Lead Member of the Examining Authority
Five Estuaries Windfarm DCO
National Infrastructure Planning
Temple Quay House
2 The Square, Bristol
BS1 6PN

Our Ref 20048269
PINS Ref: EN010115
Date: 3 March 2025

Planning Act 2008**Application by Five Estuaries Offshore Wind Farm Limited for an order granting development consent for the Five Estuaries Offshore Wind Farm project.**

ANNEX B: OUTLINE OPERATIONAL DRAINAGE LAYOUT

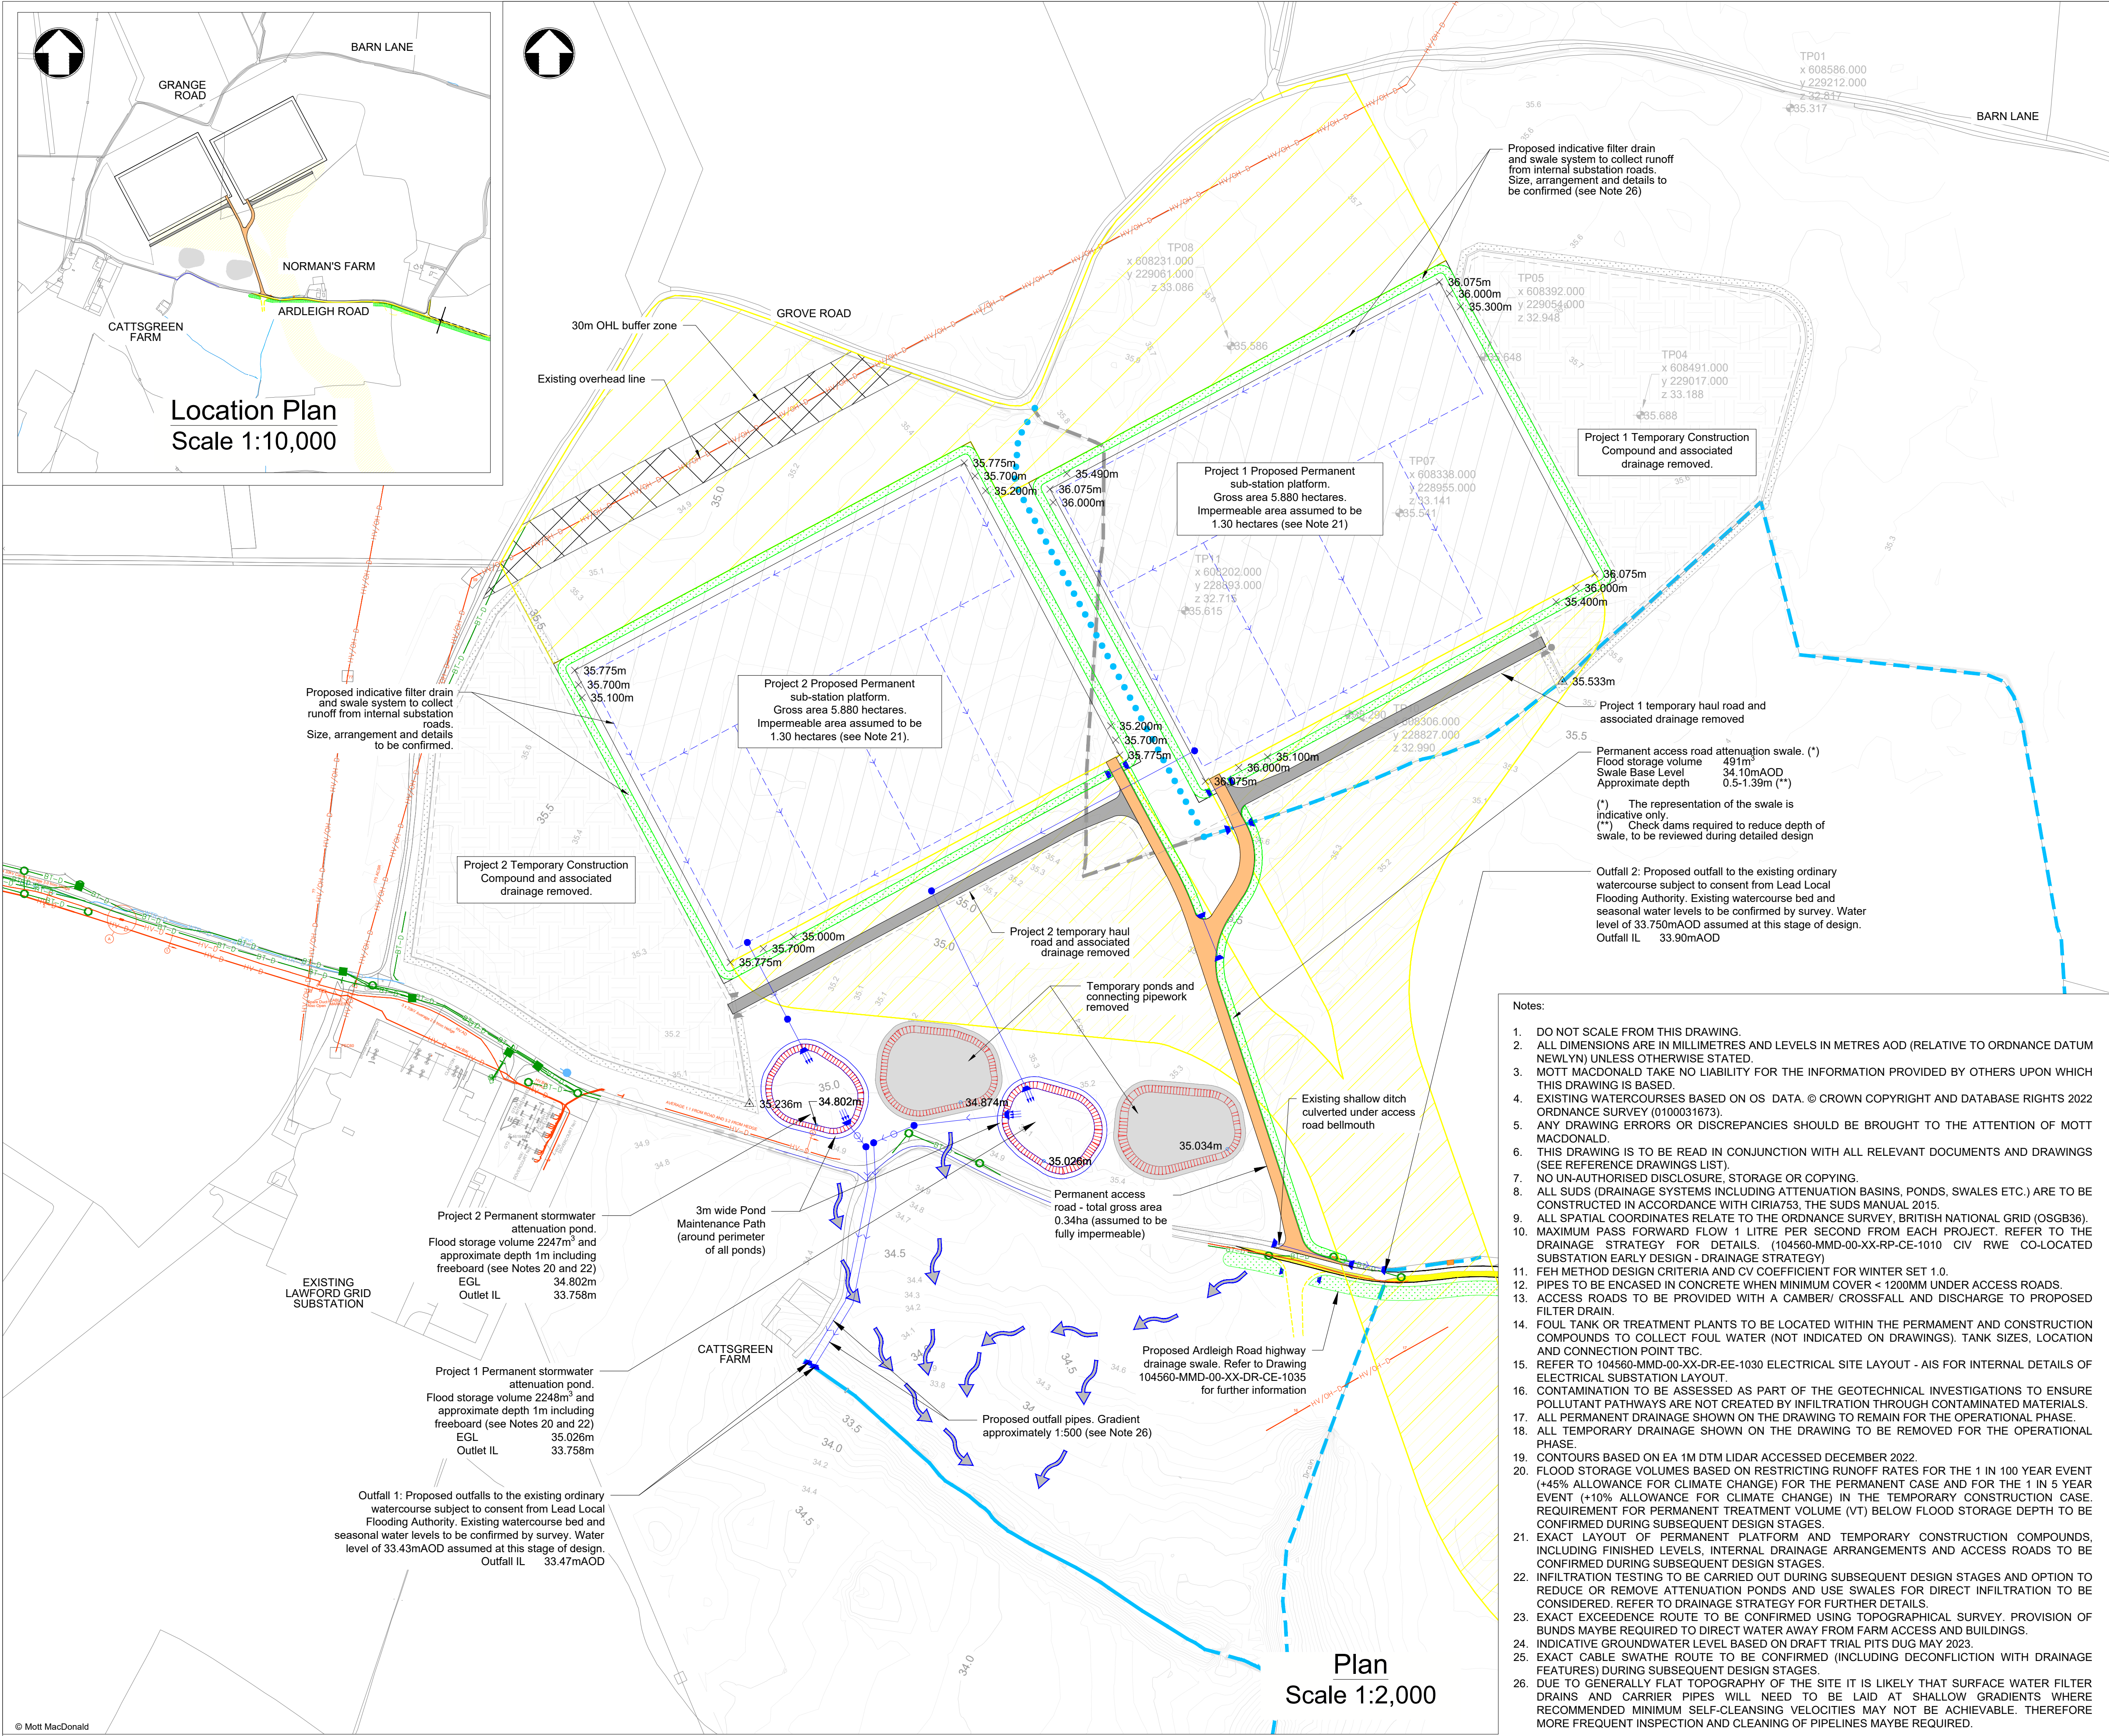
LLFA Deadline 5' comments	Applicant's email response dated 18 February 2025	LLFA further comments
In addition to the information provided we would like to see the modelling for the drainage system for all events up to the 1in100 plus climate change.	We would usually expect to provide this in detailed design (e.g. a table with 1 in 1, 1 in 5, 1 in 10, 1 in 50 and 1 in 100), however at this stage (concept design) the drainage design has been based on the extreme event for the permanent case, and 1 in 5 years for the temporary case.	The LLFA considers that these should be provided as part of a Surface Water Drainage Strategy, to be submitted to and approved by LLFA, prior to commencement.
Confirmation of the discharge rate is required.	MicroDrainage has been used to provide an initial estimate of attenuation storage volumes and associated attenuation feature dimensions required to limit surface water discharge from the site to 1 l/	This will need to be demonstrated in the detailed surface water drainage scheme, to be submitted to and approved by LLFA, prior to commencement.

How will the permanent access road drain, will it be unrestricted? Is the swale sufficient treatment for the road? What is the expected usage?	Yes the swale will be design for the road and interception will be included. The substation would be unmanned during standard operation with routine visits from maintenance staff.	This will need to be demonstrated in the detailed surface water drainage scheme, to be submitted to and approved by LLFA, prior to commencement.
